**SOIL, GEOLOGY, GEOLOGIC HAZARD,
AND WASTEWATER STUDY
ARVIDSON SUBDIVISION
2310 WAKONDA WAY
MONUMENT, COLORADO**

Jenna and Matthew Arvidson
2310 Wakonda Way
Monument, Colorado 80132

September 14, 2017

LEGEND:

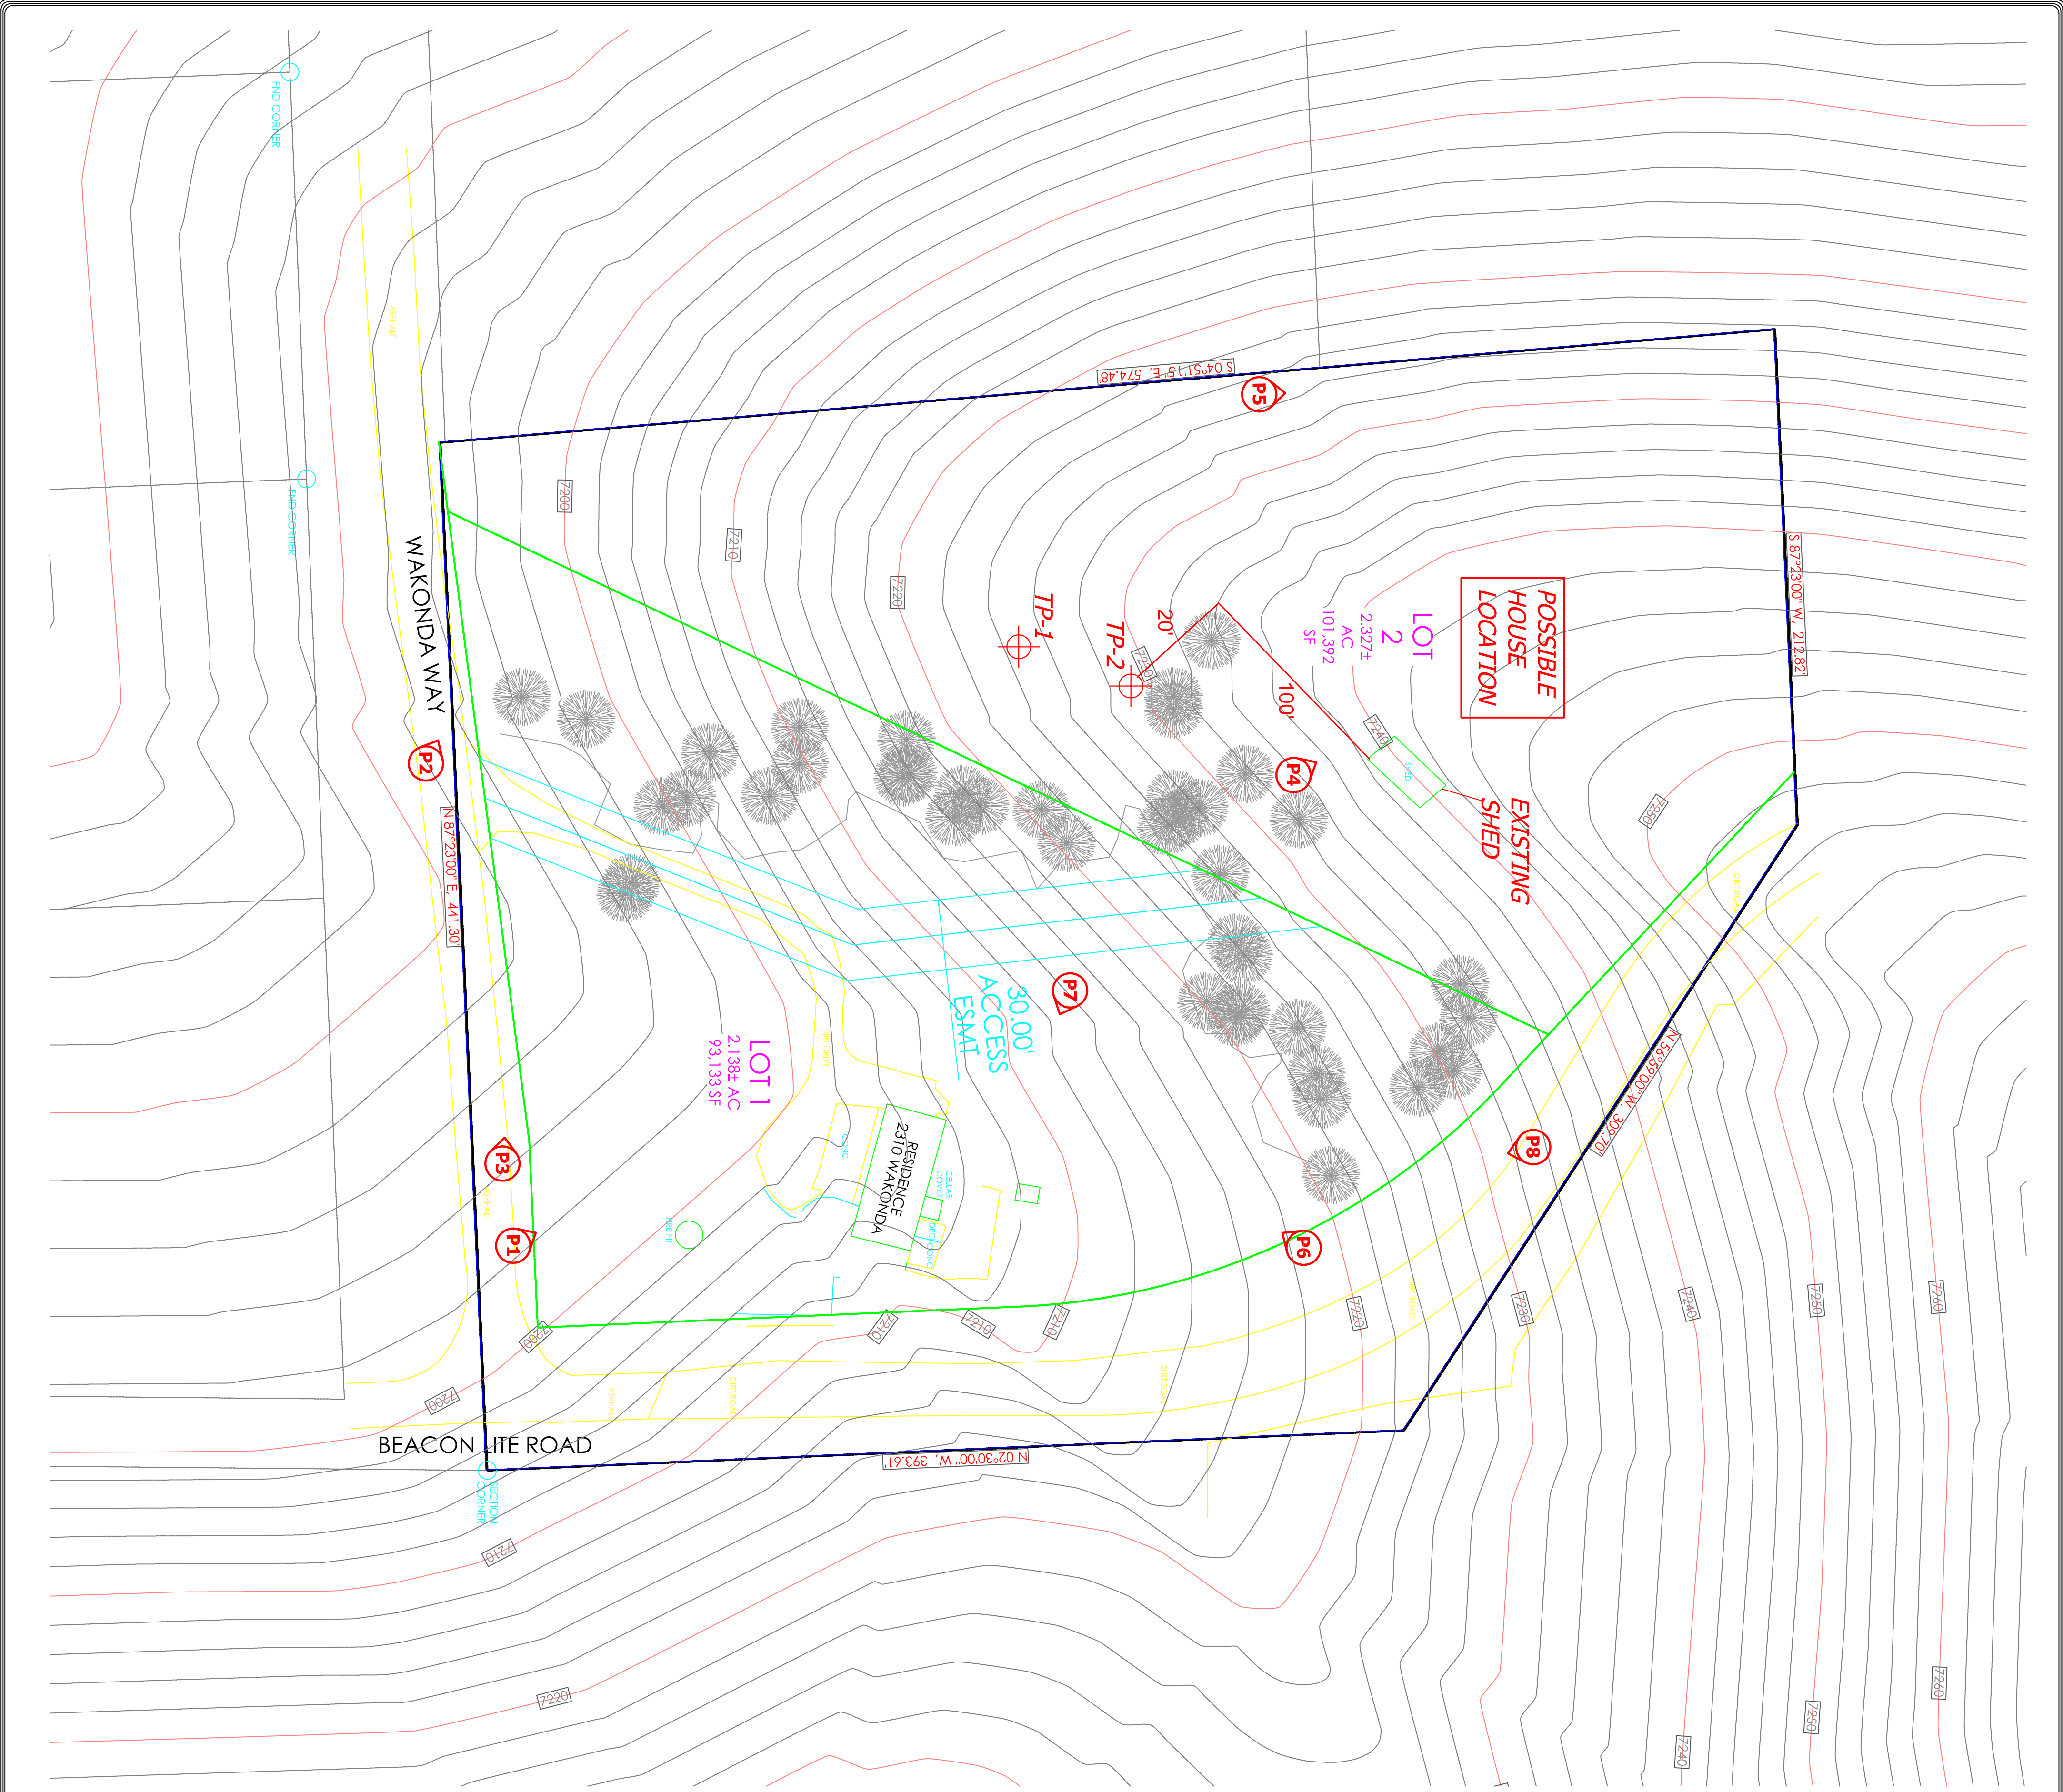
only soil types are shown,
please show other
constraints as listed in the
report.

please call out
these areas
on one of the
exhibits

Please call out
extents on
one of the
exhibits.

please show
on the exhibit.
